**Project# 1004404**

07DRB-70296 VACATION OF PUBLIC EASEMENT

07DRB-70297 BULK LAND VARIANCE

07DRB-70298 MINOR - PRELIMINARY/ FINAL PLAT APPROVAL

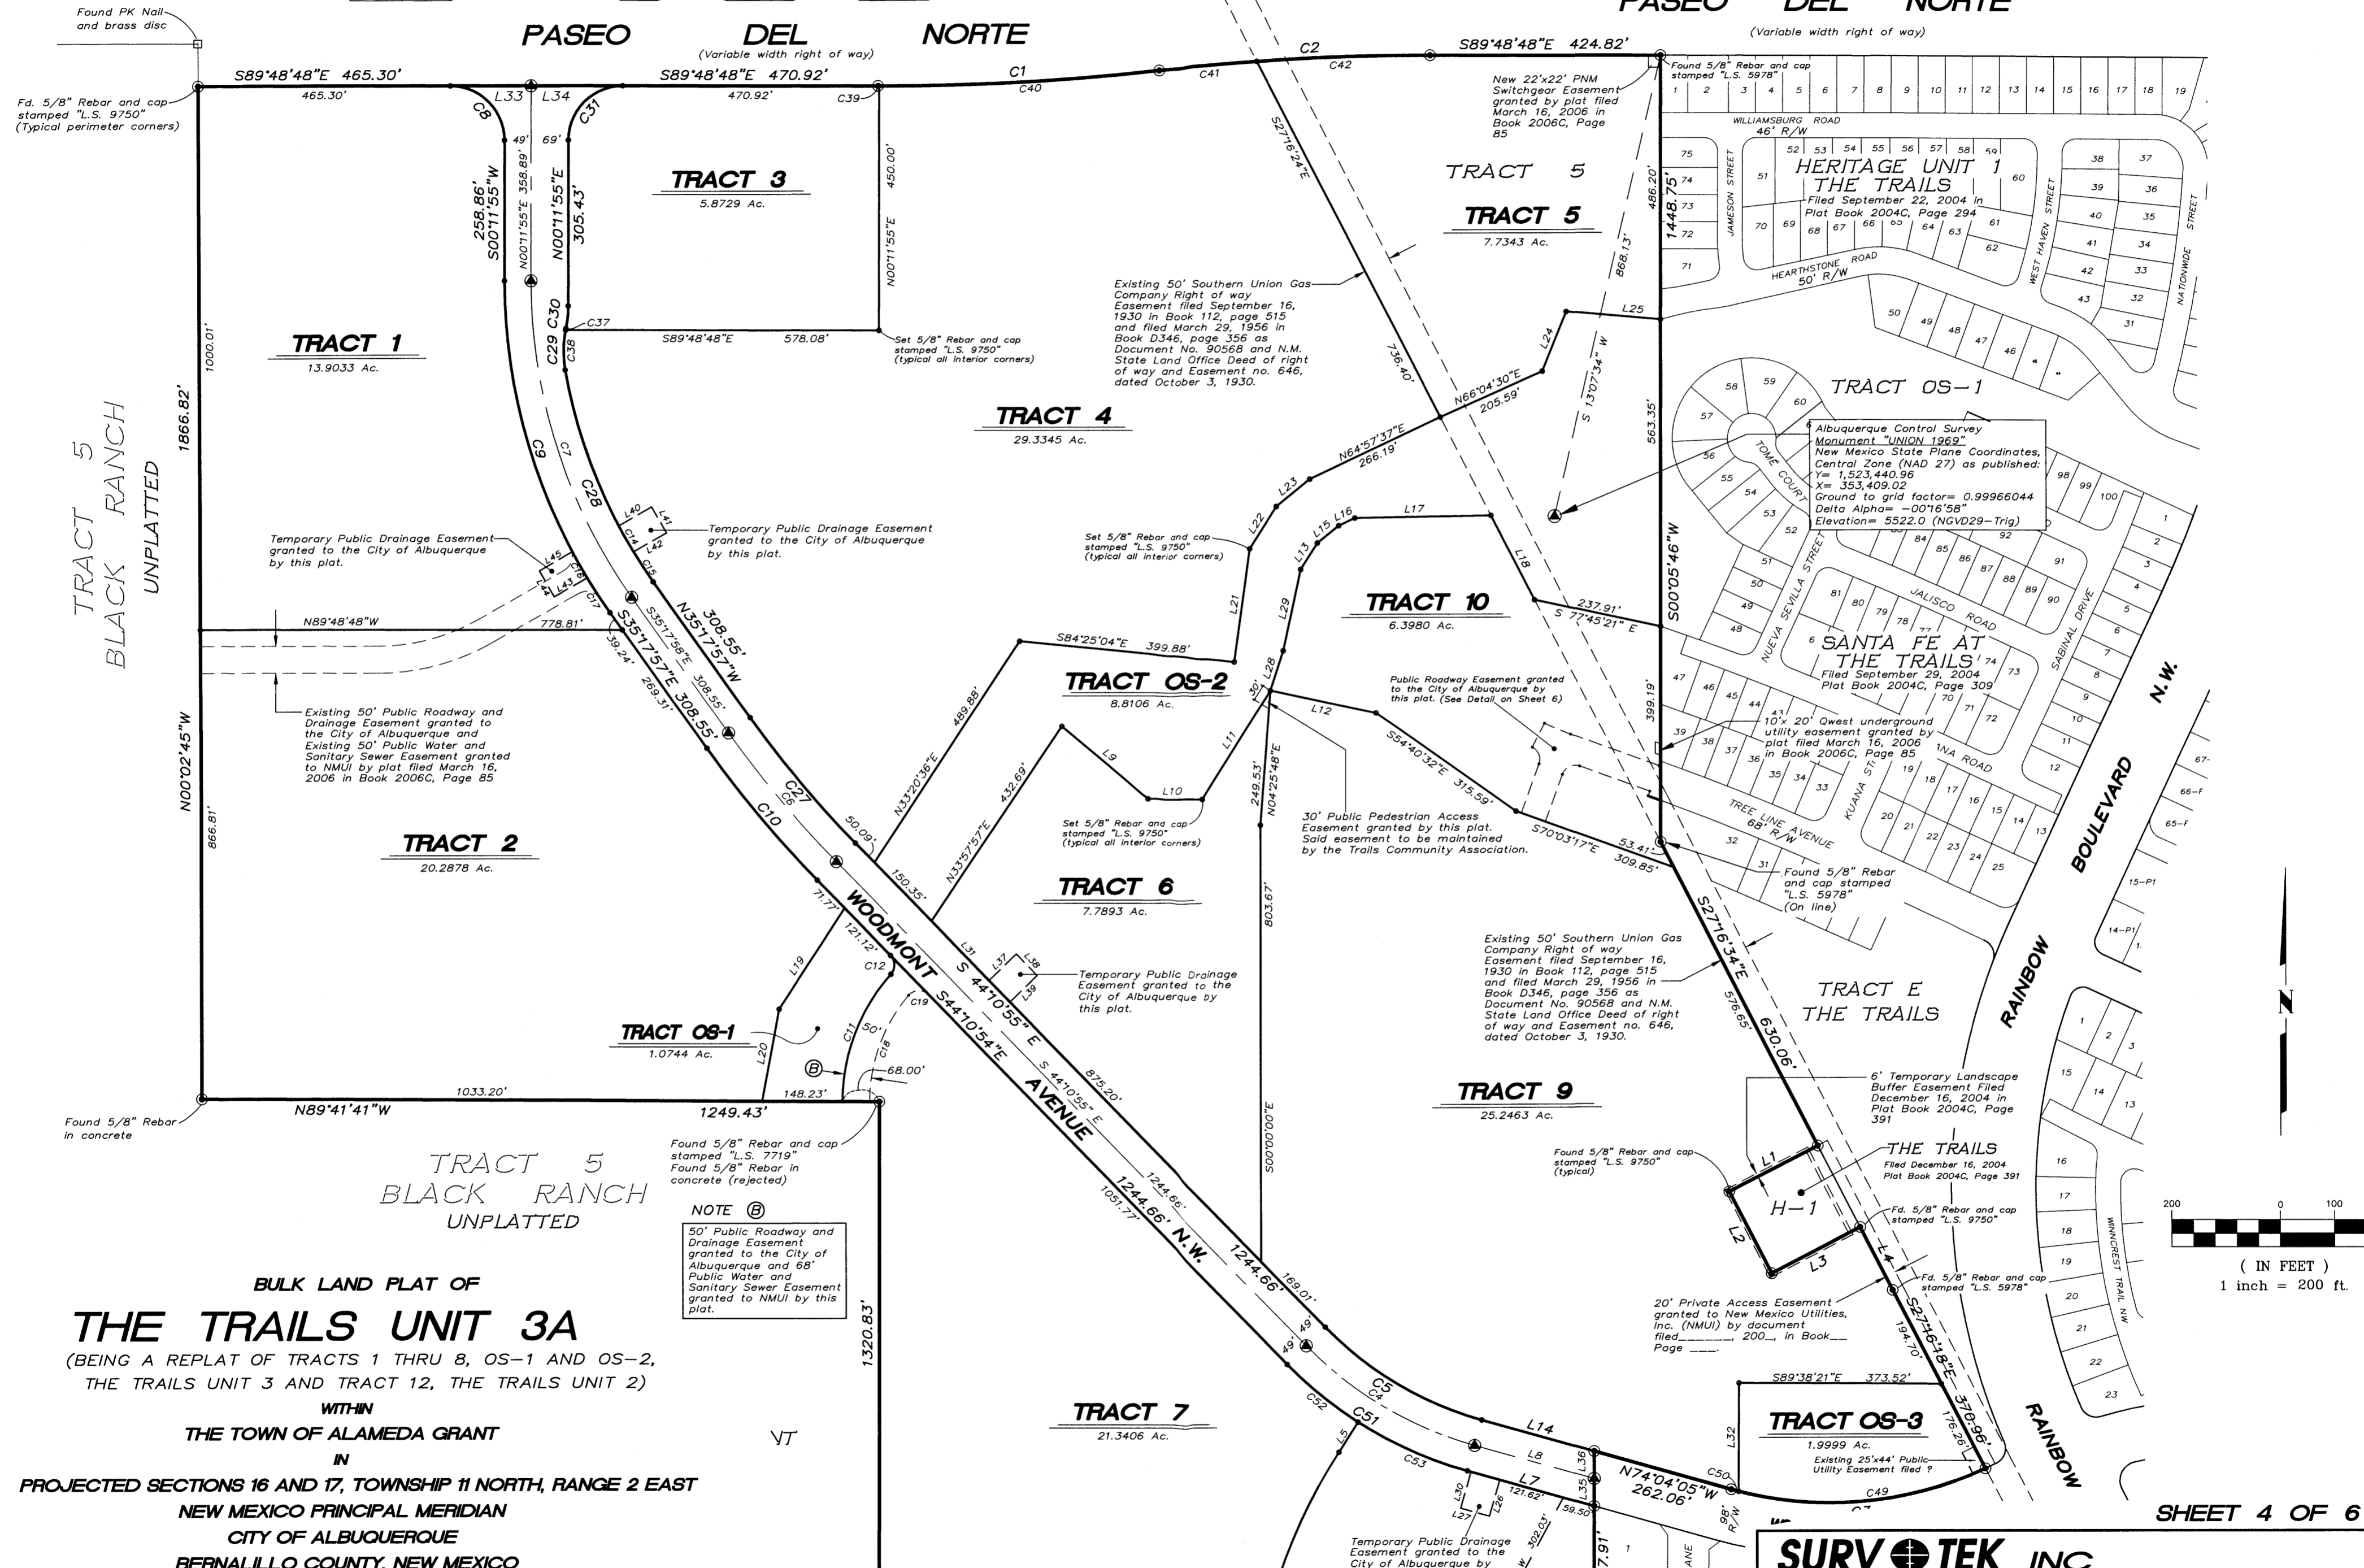
1  
Alternate outfall easement required for well site storm drain (Tract H-1)  
No objection to Bulk Land Variance request.  
Public drainage easement required on Tract 11.

*No objection to BLV  
Need public drainage esmt on tract 11*

VACATION EXHIBIT B
Date 10/31/07

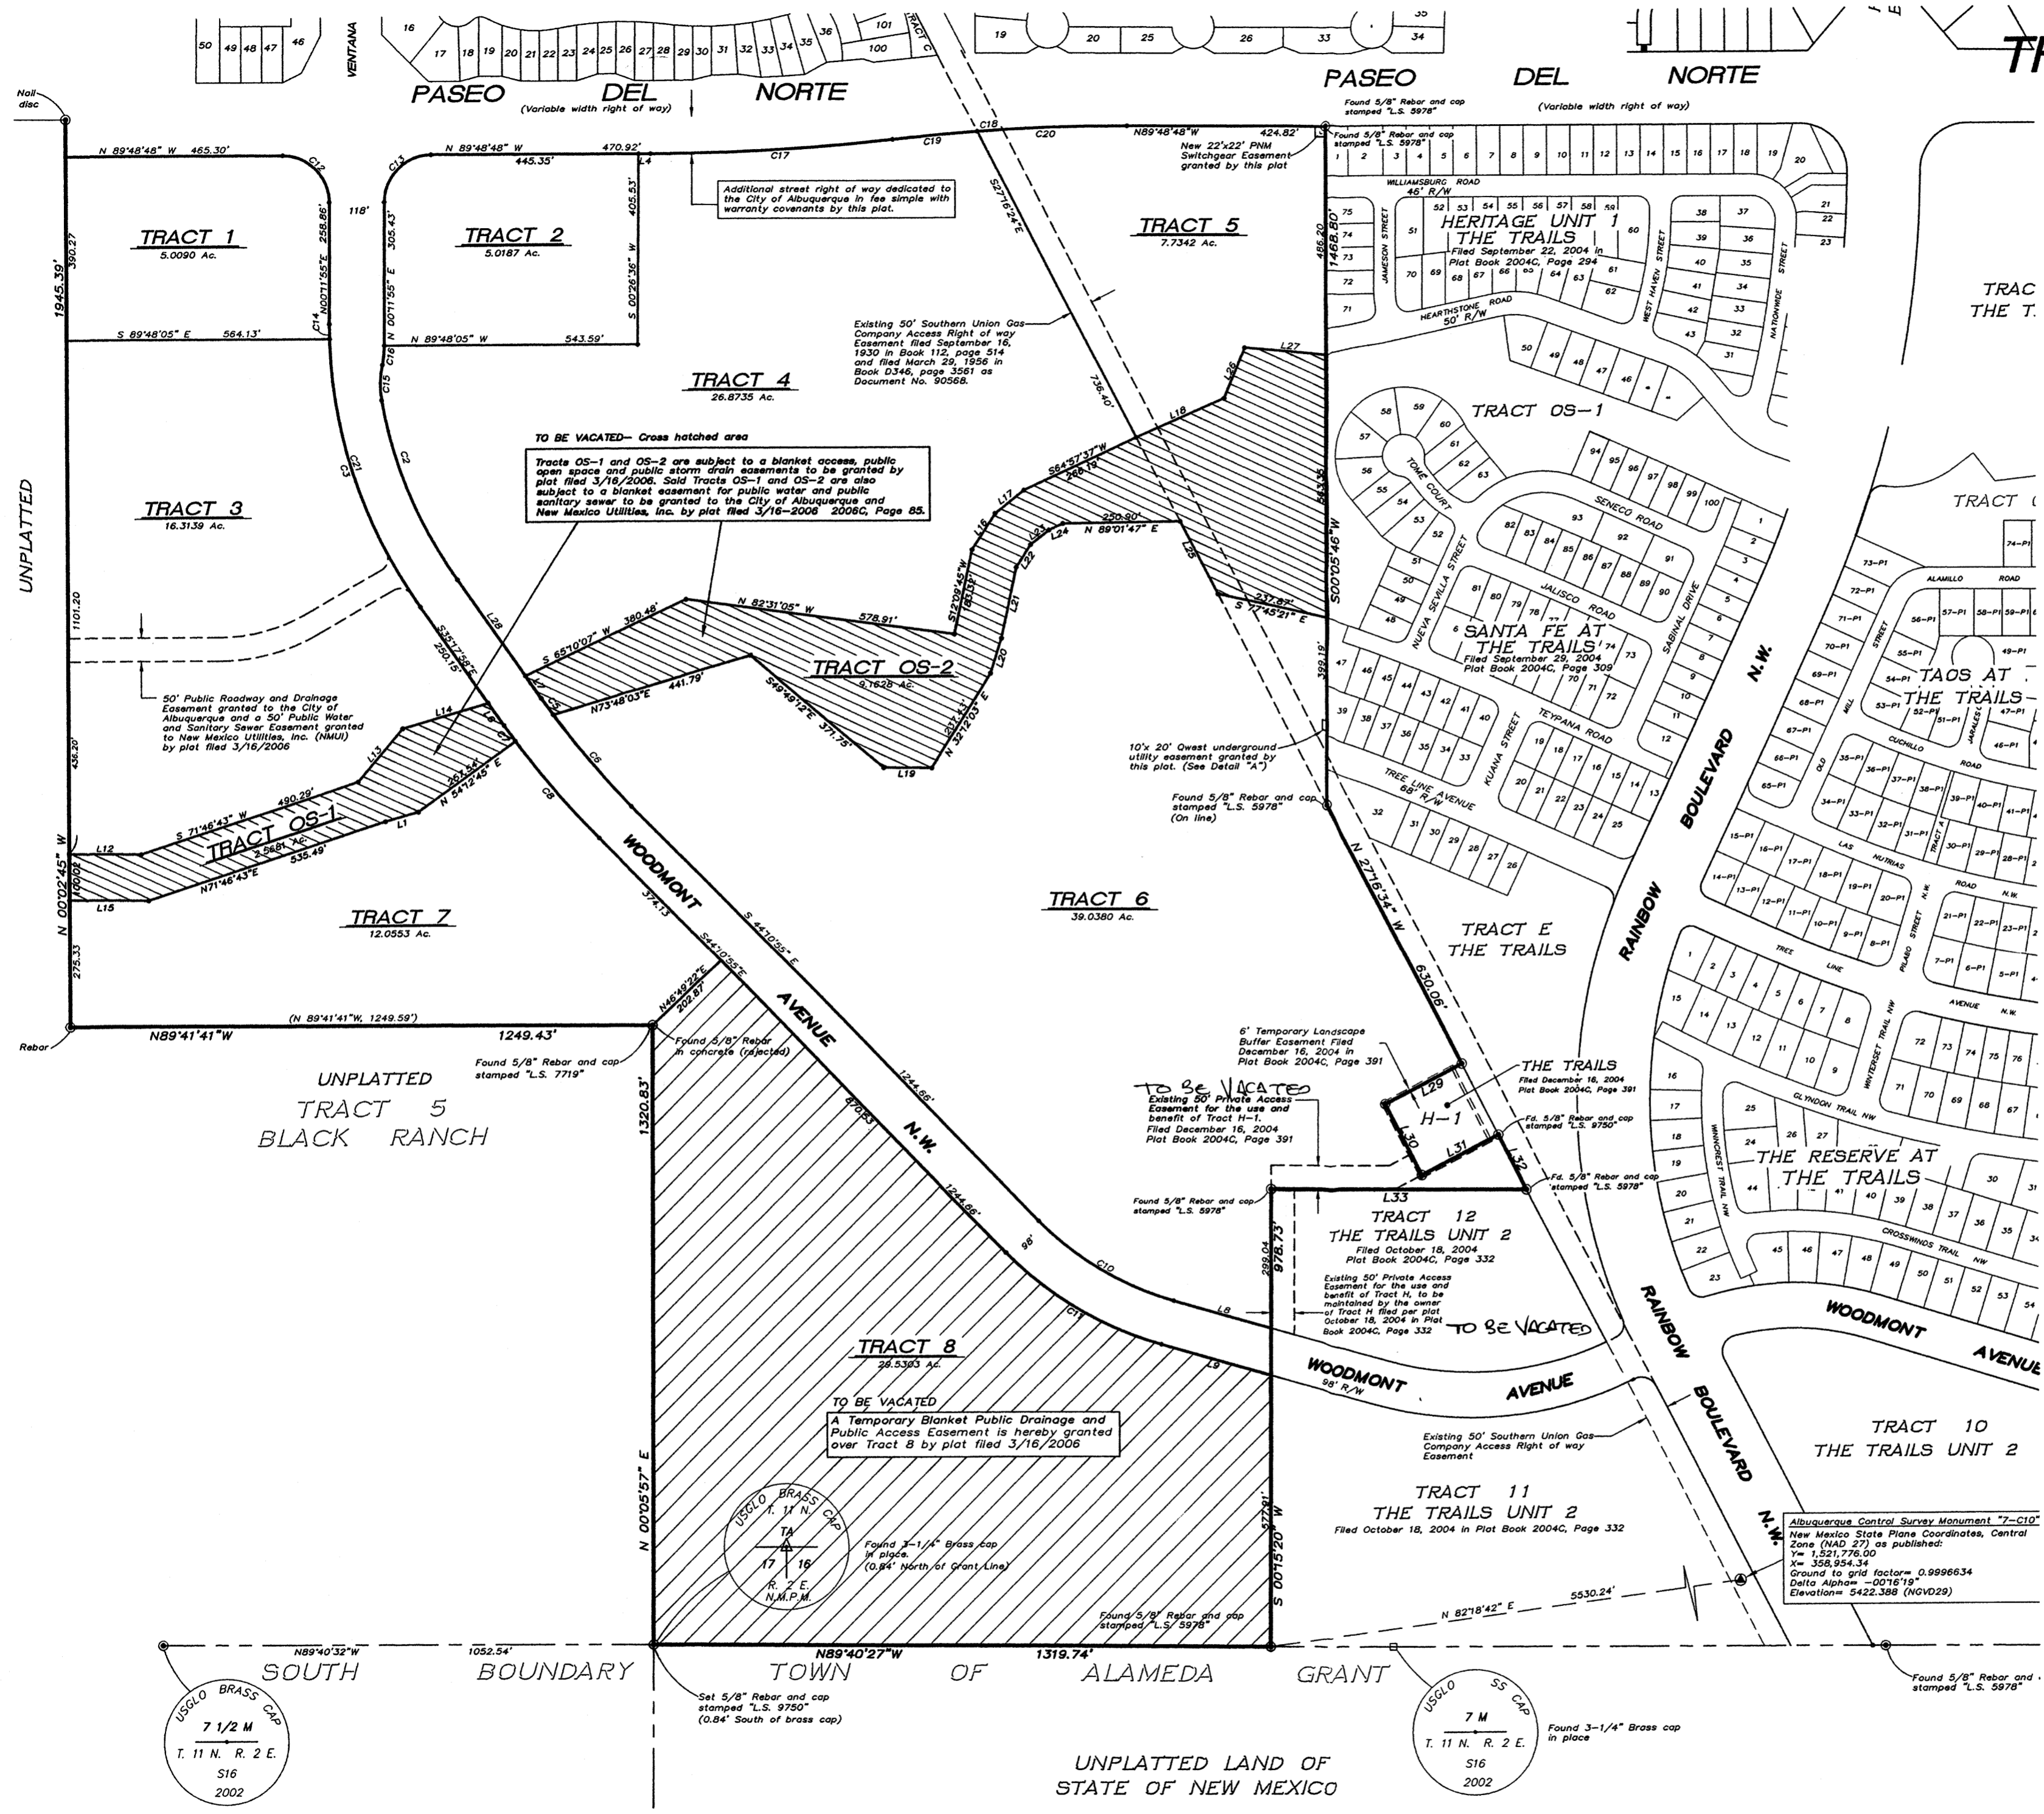
The easements to tract H-1 must remain in place.  
If Treeline is going to be a public road, then no easement can be granted to NMUI.
